Our ref: [REDACTED]
Your ref: EN010153
Date: 04 March 2026

ENVIRONMENT AGENCY RESPONSE TO DOCUMENTS SUBMITTED AT DEADLINE 4.

FRODSHAM SOLAR PROJECT, FRODSHAM MARSHES

Figure Title  
Illustrative Environmental Masterplan  
Key Plan

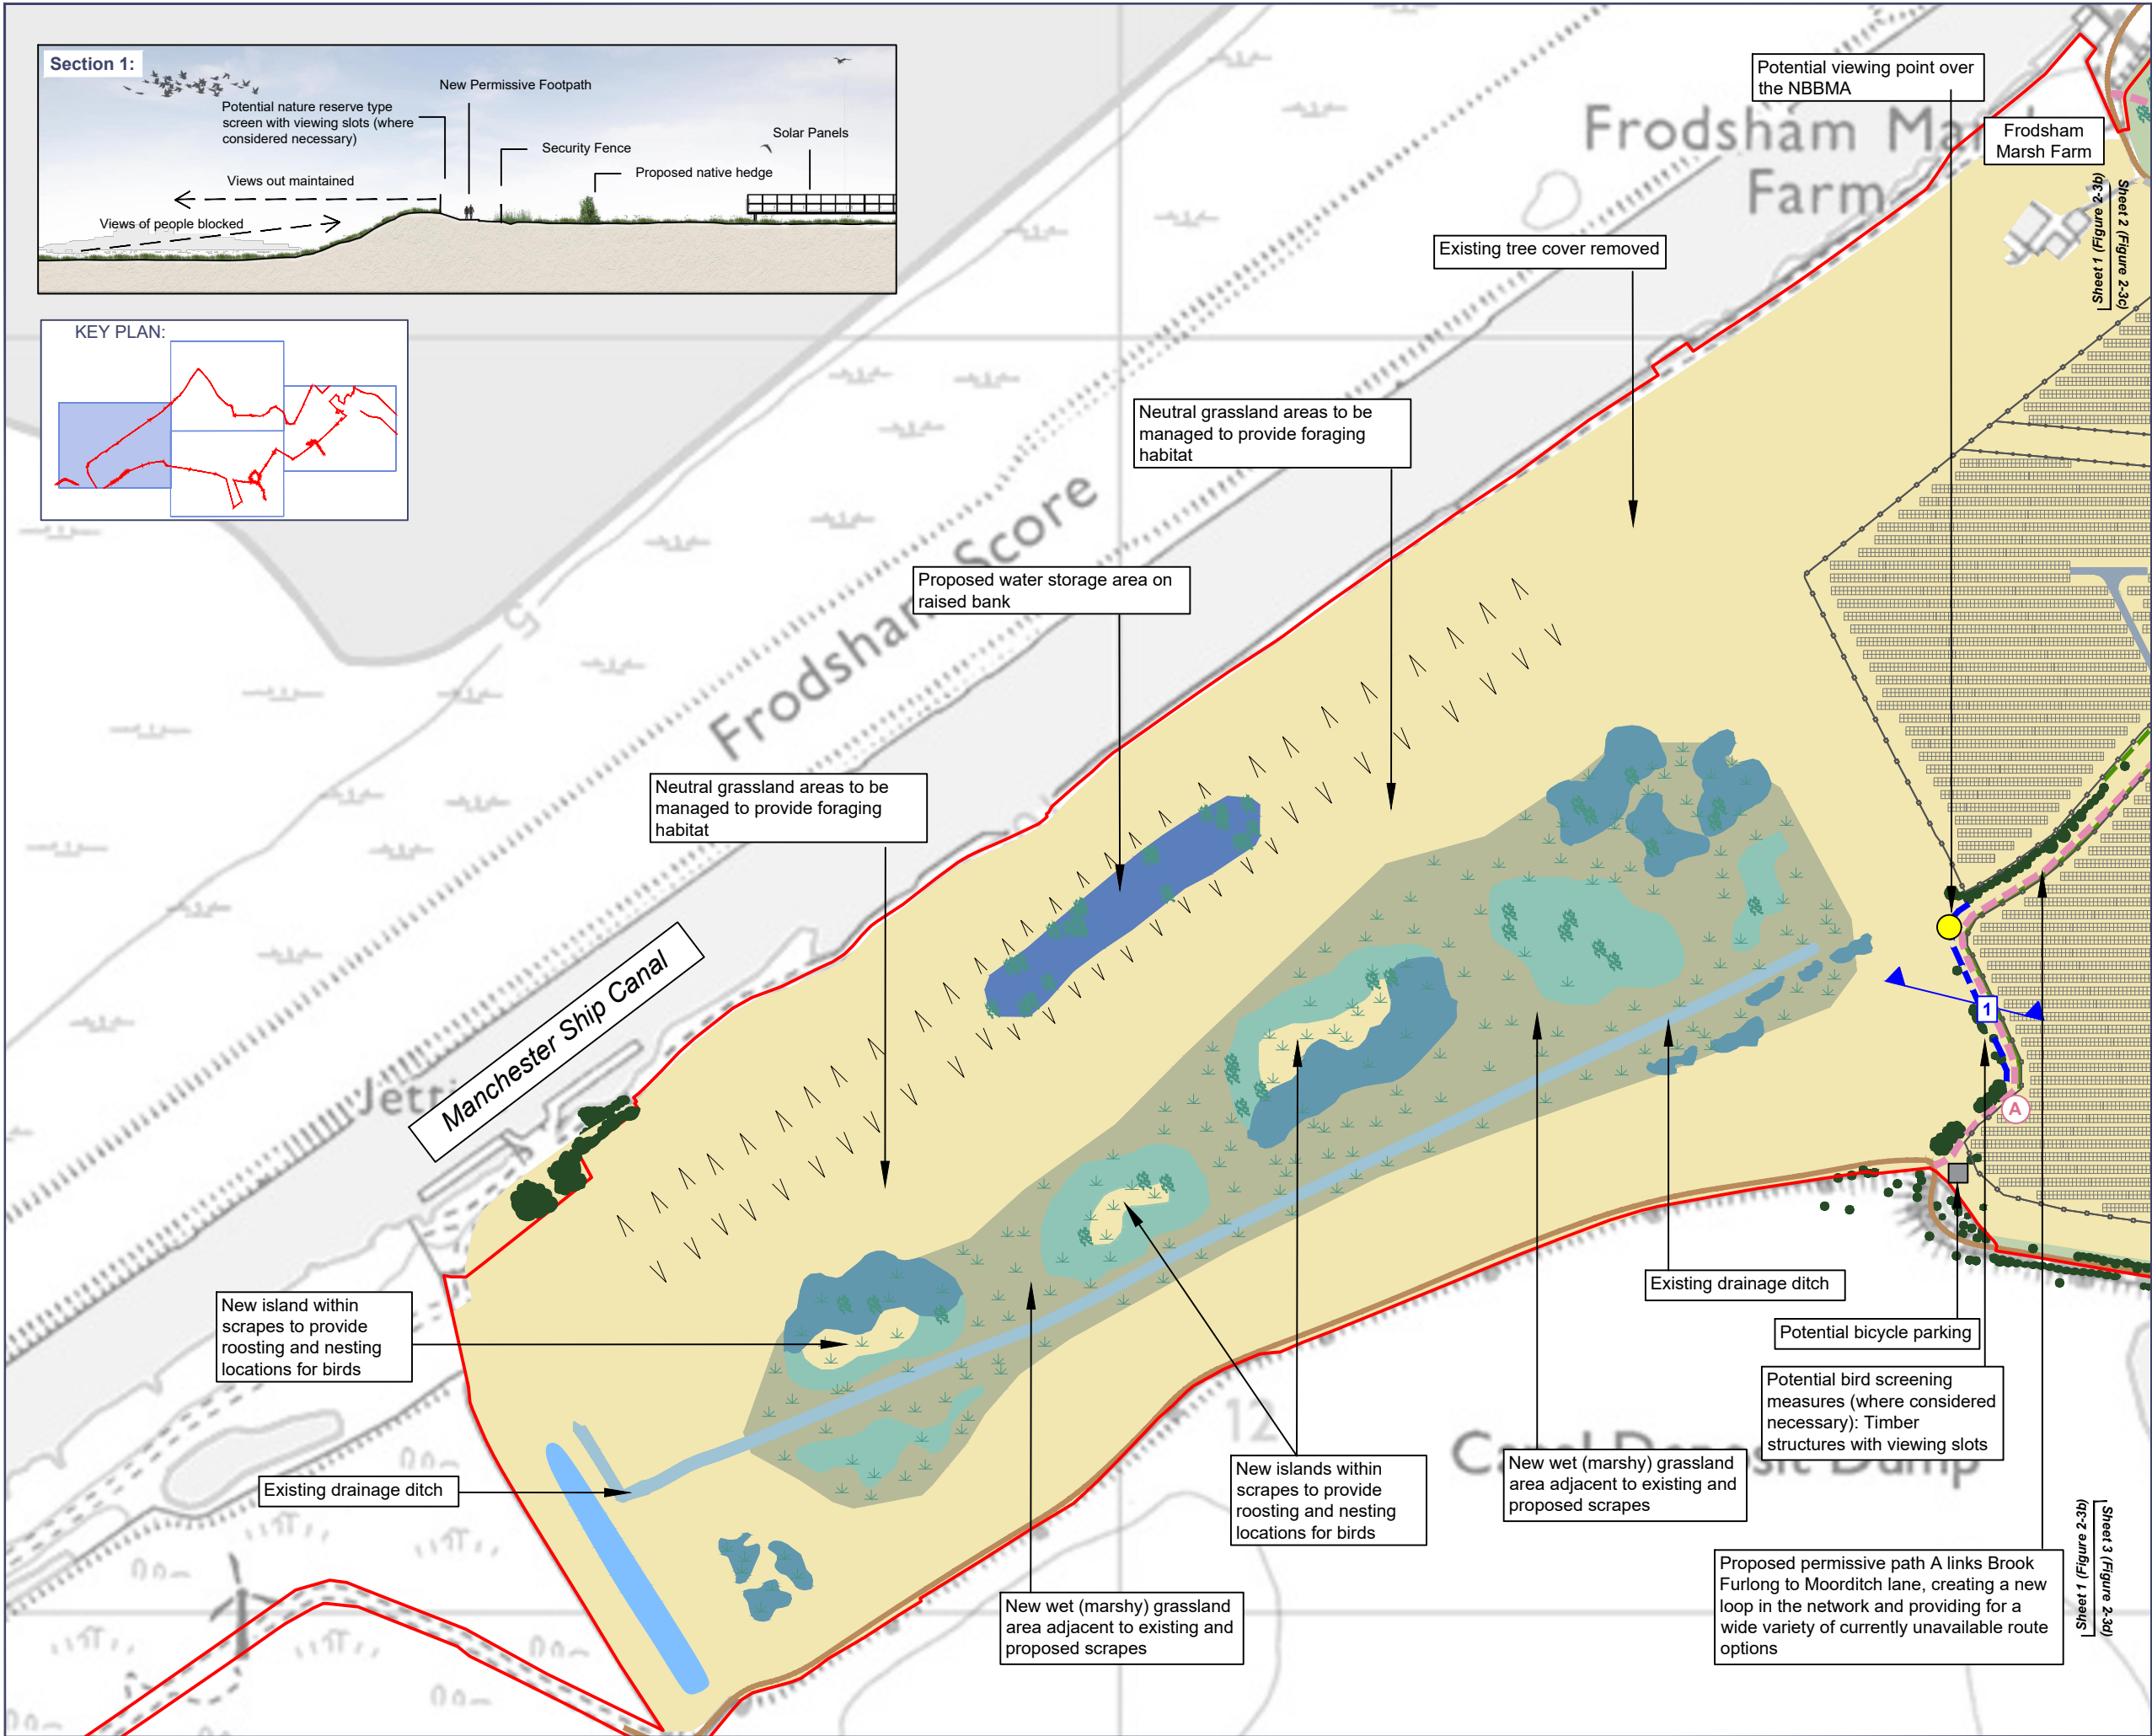
Figure 2-3a

The order limits exclude asset 174693. In our latest email to the applicant, we suggested that activities in proximity to this asset would need to be assessed, but this is not needed. We also note the key does not imply the ponds are new (approximate NGR: SJ4992879181 and SJ5135279100 respectively).

**CROSSING CP22 PROPOSED SECTION B-B
ALTERNATE ARRANGEMENT
1:50**

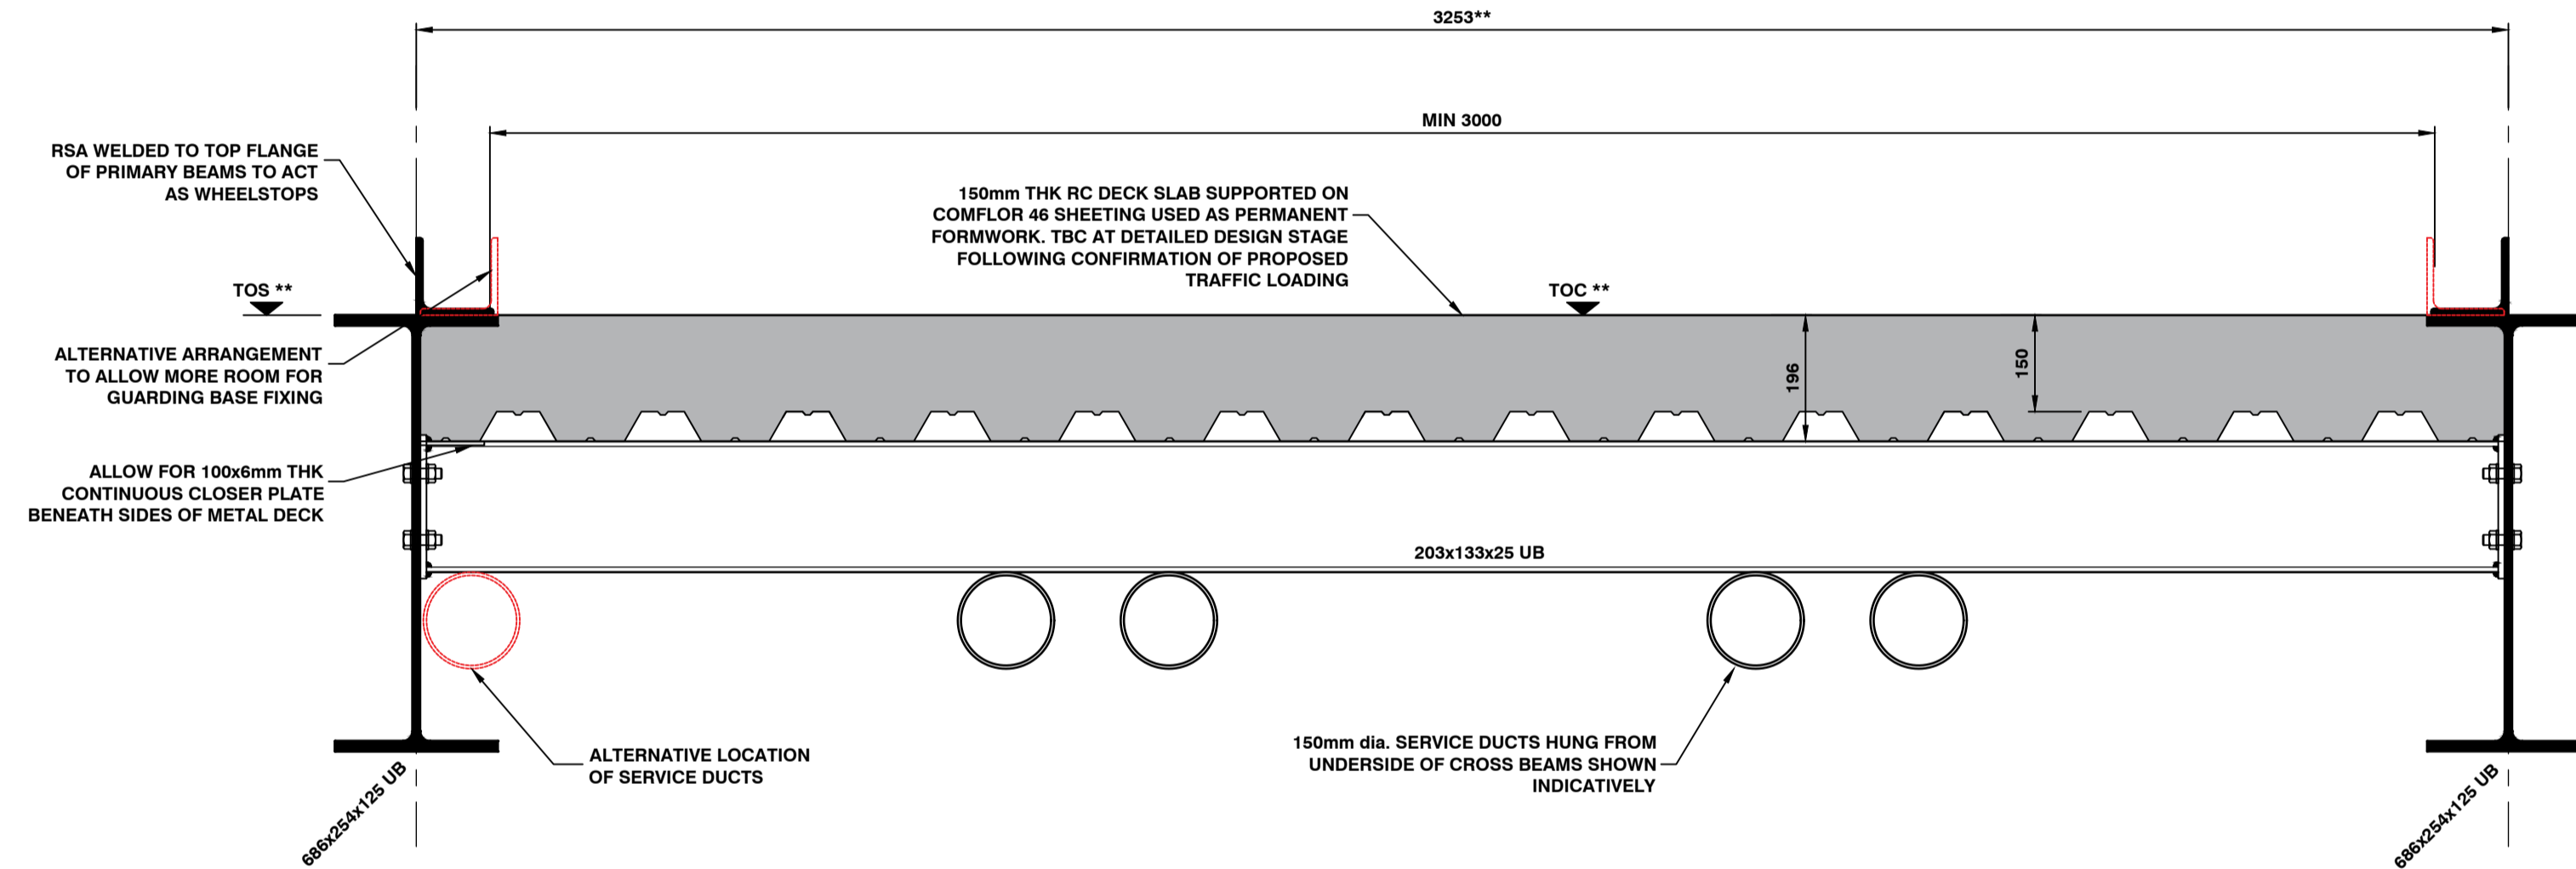
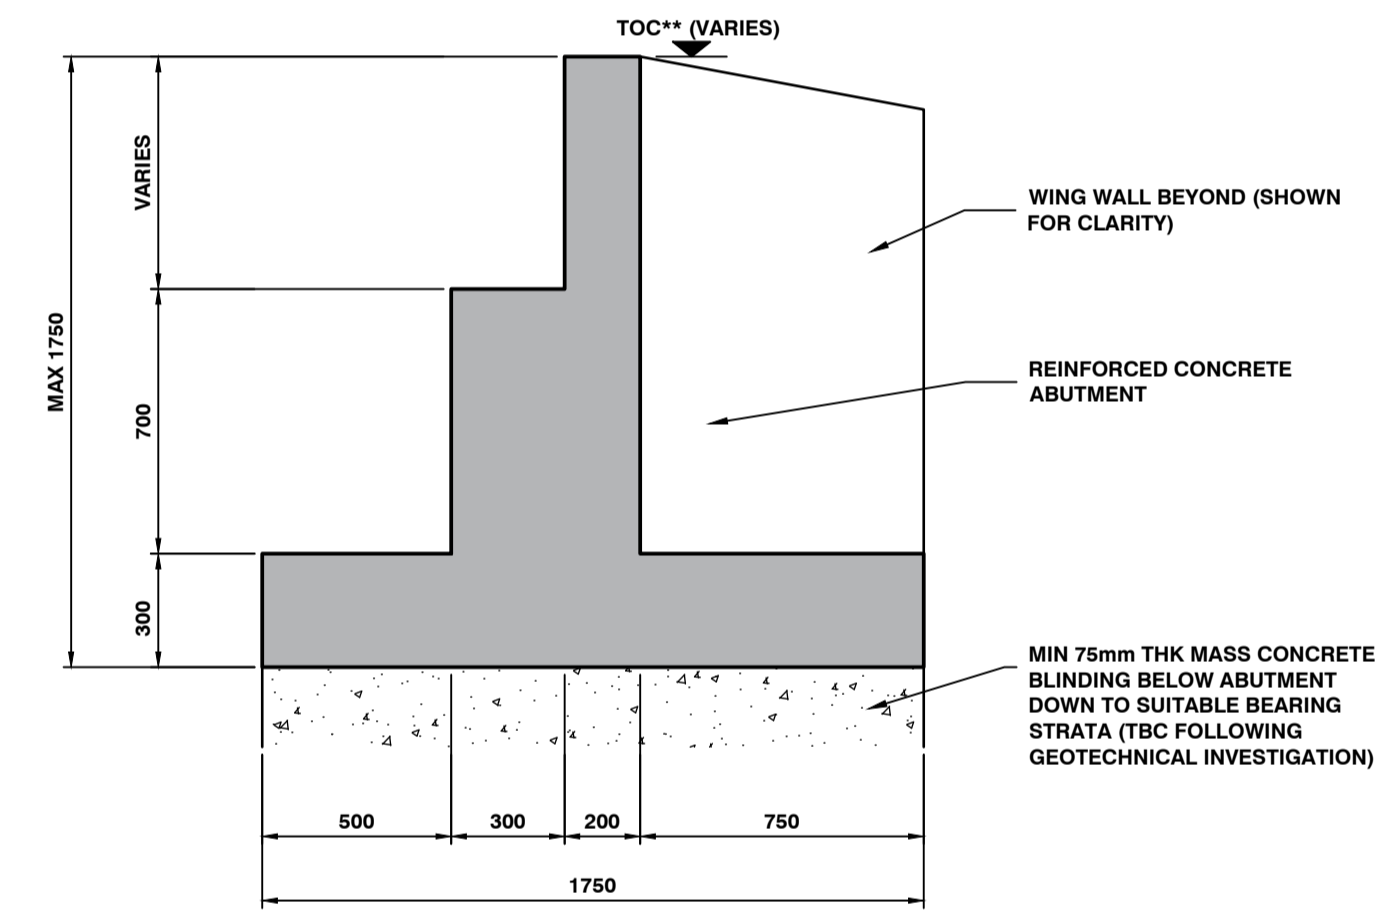
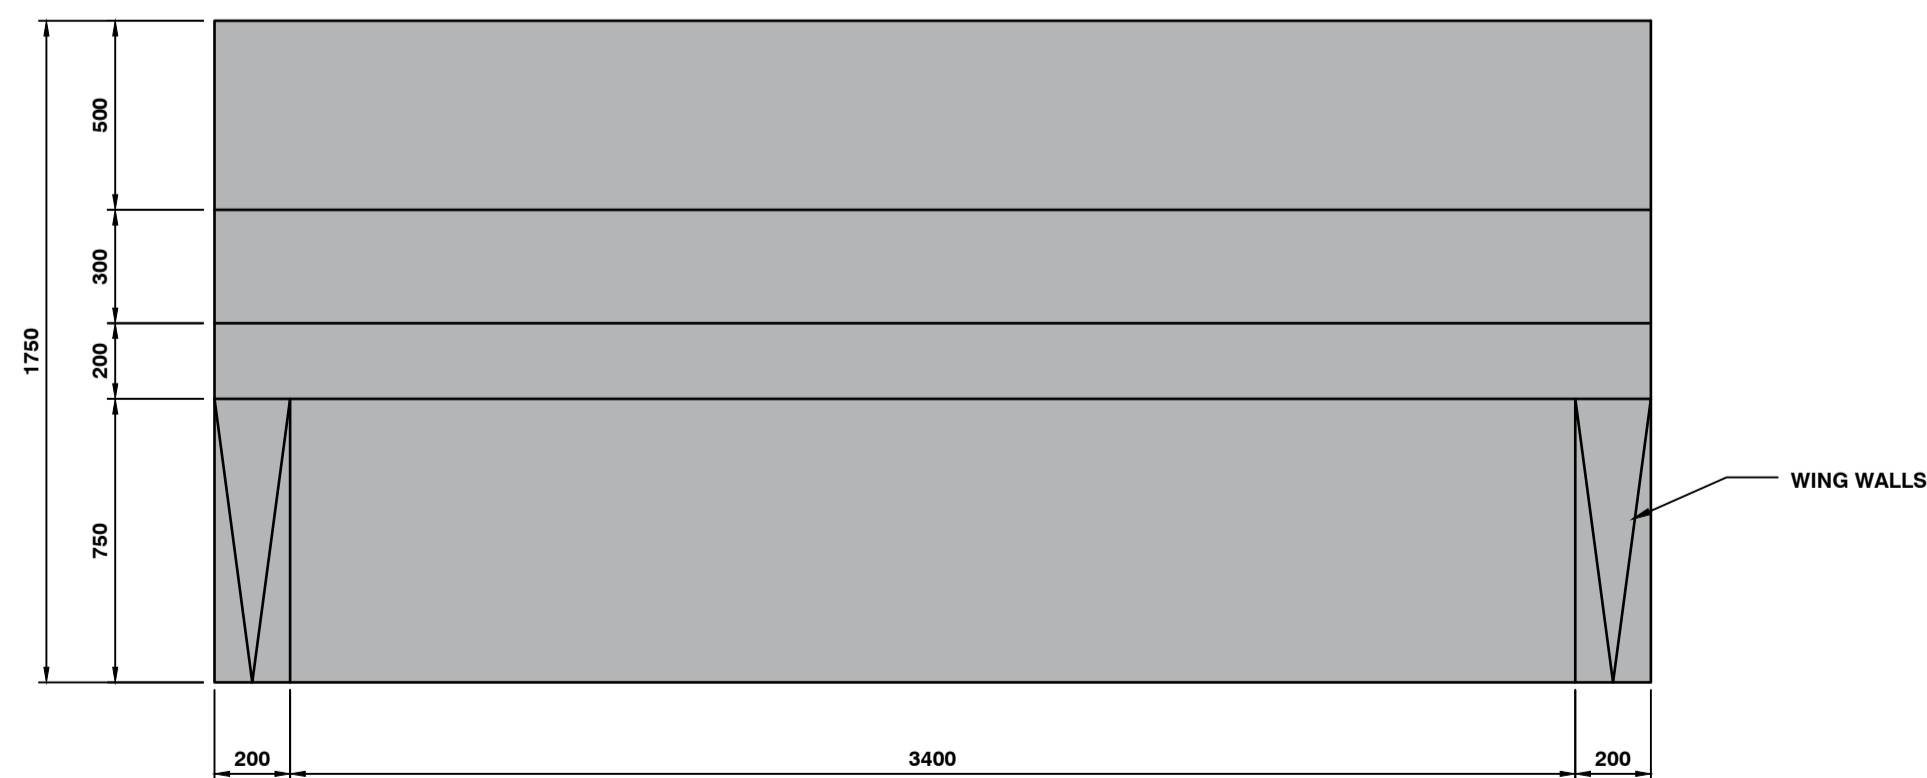
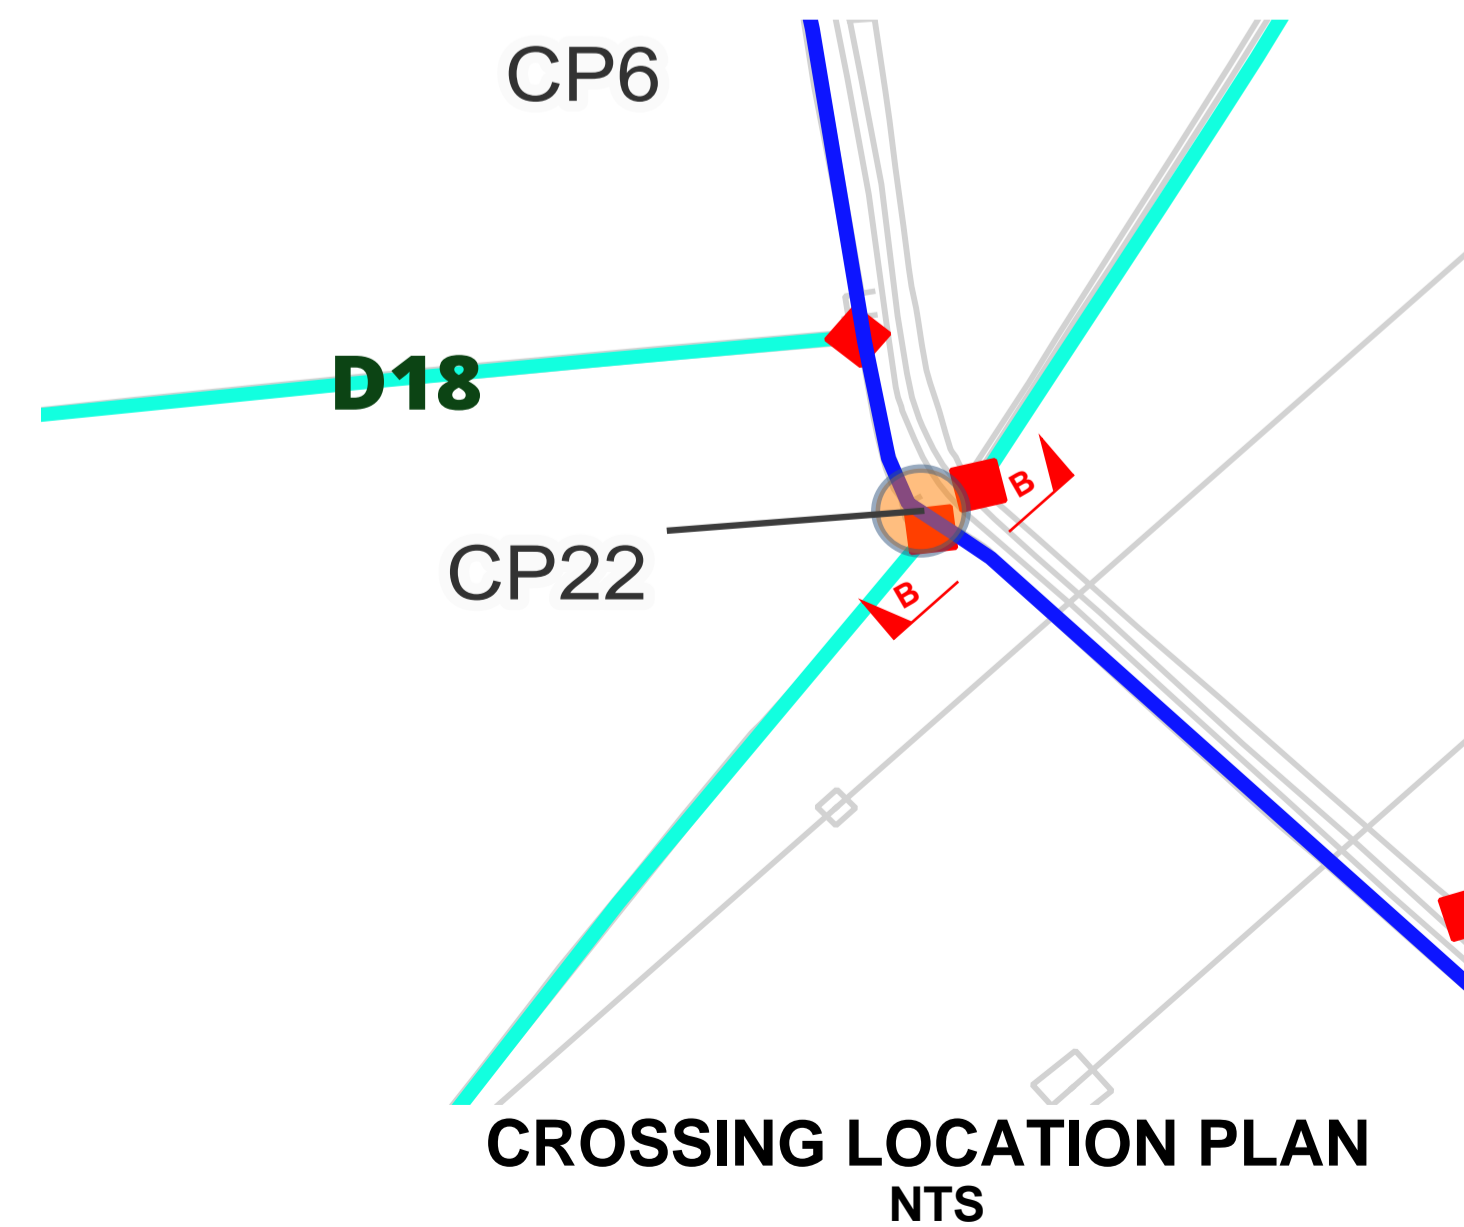
The Applicant has proposed localised lowering of the eastern bank for CP22. The applicant submitted to us the document 'Proposed Crossing CP22 Elevation & Sections drawing 14740-WCD-XX-XX-SK-S-003'. We identified this design results in approximately zero freeboard above the Ince and Frodsham fluvial design flood level on the eastern side of the crossing Proposed Crossing CP22.

We acknowledge there are site-specific constraints and the applicant is endeavouring to minimise the loss of floodplain storage for the Mersey Tidal and Weaver design flood events. As this proposed design does not demonstrate to have

600m freeboard above the Ince and Frodsham fluvial design flood level the CP22 design is not acceptable.

To resolve this issue, CP22 design should be updated to include a 300mm freeboard above the design flood level of Ince and Frodsham fluvial model. We anticipate this update will prevent the need to excavate into the northeastern flood asset (eastern bank) and will hopefully address potential legacy issues relating to retention of the crossing after decommissioning.

However, we are willing to accept a compromise on the freeboard, allowing 300mm for the crossing above the design flood level for CP22 which is a reduction from 600mm freeboard. For context: Within the Flood Risk Assessment [[AS-027](#)] Table 1 of Appendix S Watercourse Crossing Design Justification of the Flood Risk Assessment it is implied that a 600mm freeboard would be applied above the Ince and Frodsham design flood level for crossing point CP22.
